August 9, 1996

RE: CONCEPTUAL GRADING AND DRAINAGE PLAN FOR BOB'S BURGERS, LOT 2,
BOSQUE DEL PUEBLO, (D13/D1F) SUBMITTED FOR SITE DEVELOPMENT PLAN FOR
BUILDING PERMIT APPROVAL, ENGINEER'S STAMP DATED 3/29/96.

Susan M. Calongne, P.E.
City/County Floodplain Administrator

BOB'S BURGERS
CONCEPTUAL GRADING & DRAINAGE PLAN
COORS RD. NW & EAGLE RANCH RD.

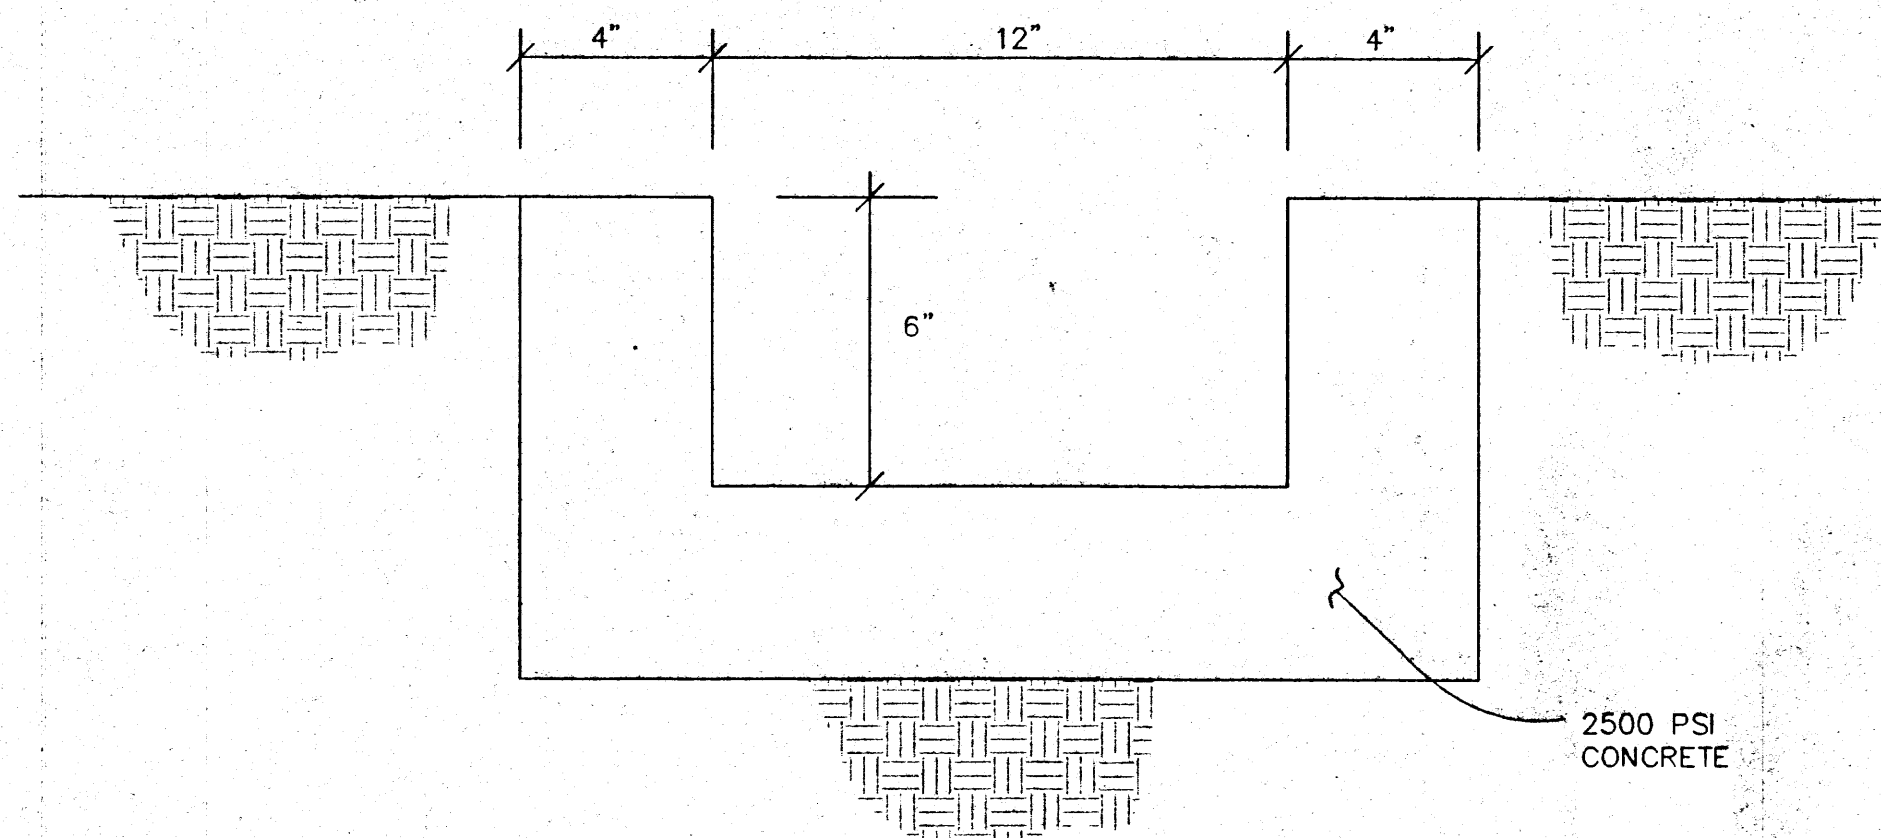
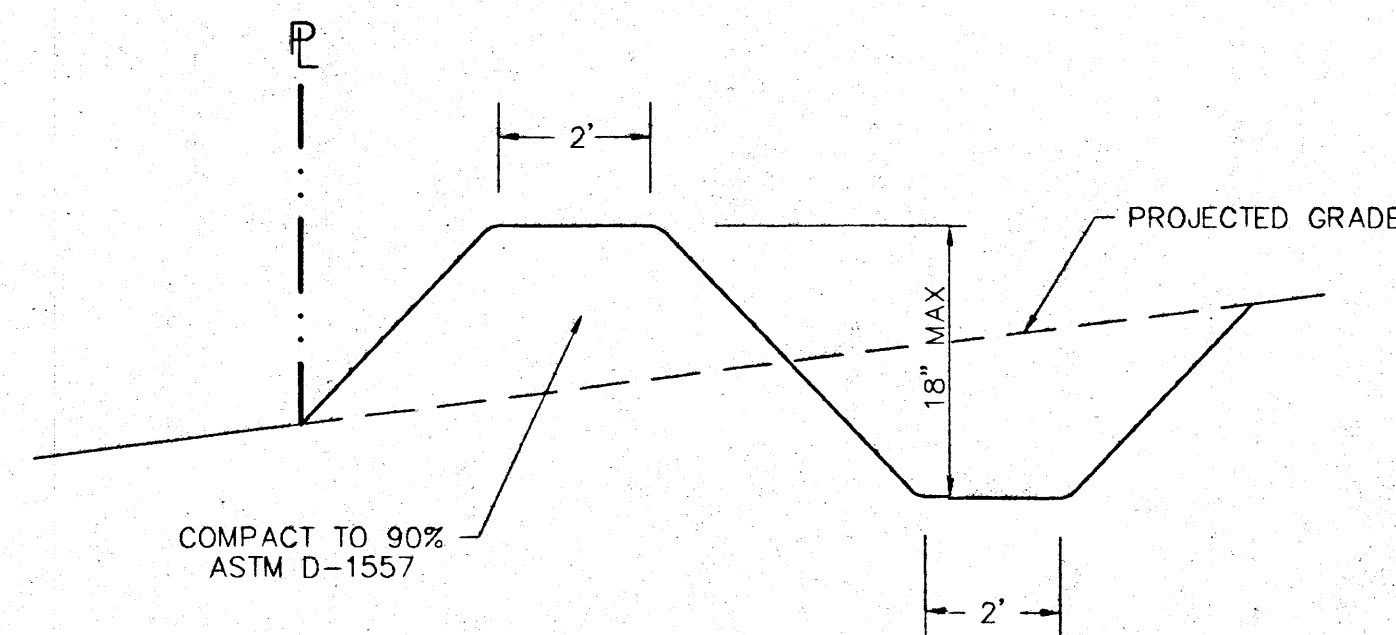
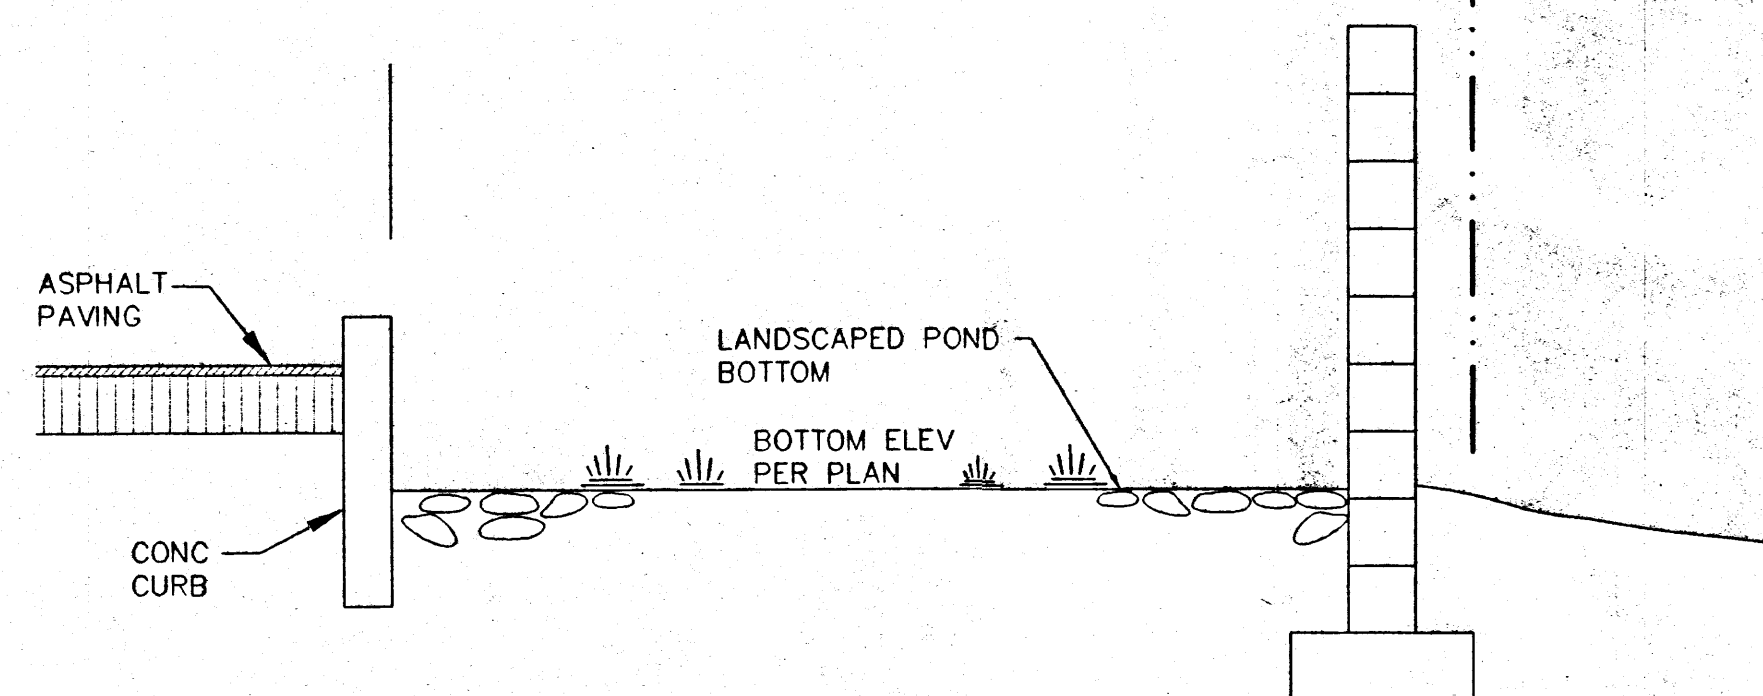
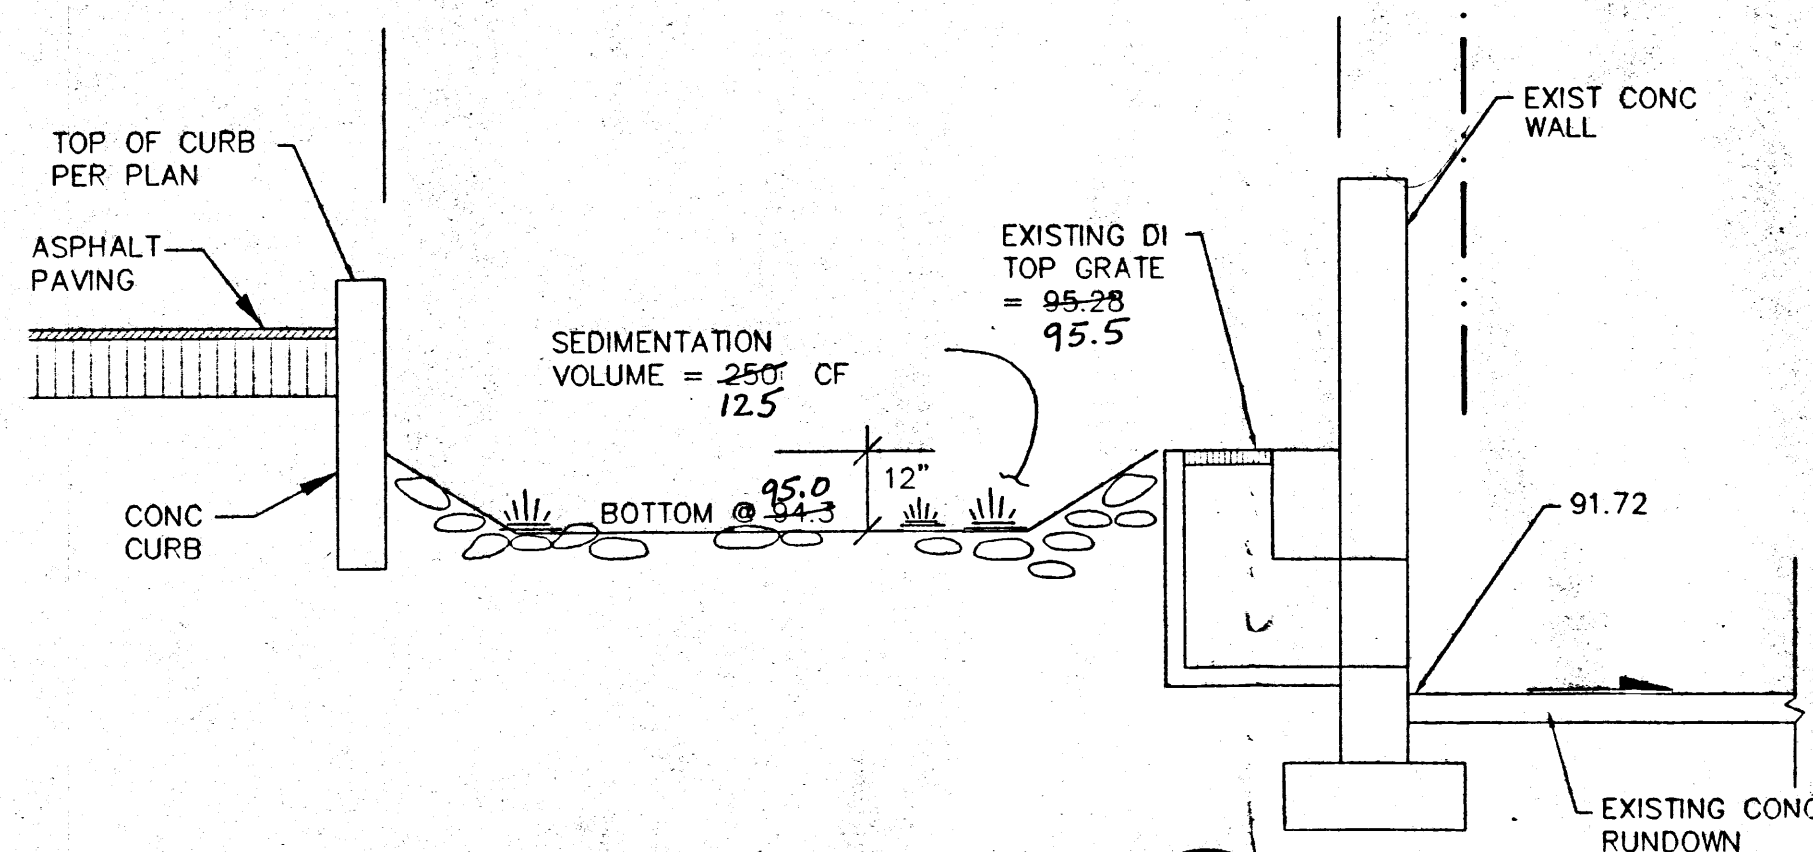
1. This development proposes to free discharge into the Corrales Main Canal. Please address downstream capacity, or reference the drainage master plan which allows free discharge from this site.

2. The plan states that minor off-site flows enter the site. Was the off-site basin included in the on-site basin runoff calculations? If not, what is the Q_{100} that is to be conveyed through the site?

3. With respect to the 15' easement located along the south property line for flows from Lot 1, what is the amount of runoff from Lot 1 and is this easement adequate? Also, please show this easement clearly.

4. Please be aware that the 25' drainage easement across the north side of the site is an AMAFCA easement for the outfall pipe from the Piedras Marcadas Dam. An encroachment license is required from AMAFCA for all proposed improvements within this easement. Please coordinate with AMAFCA.
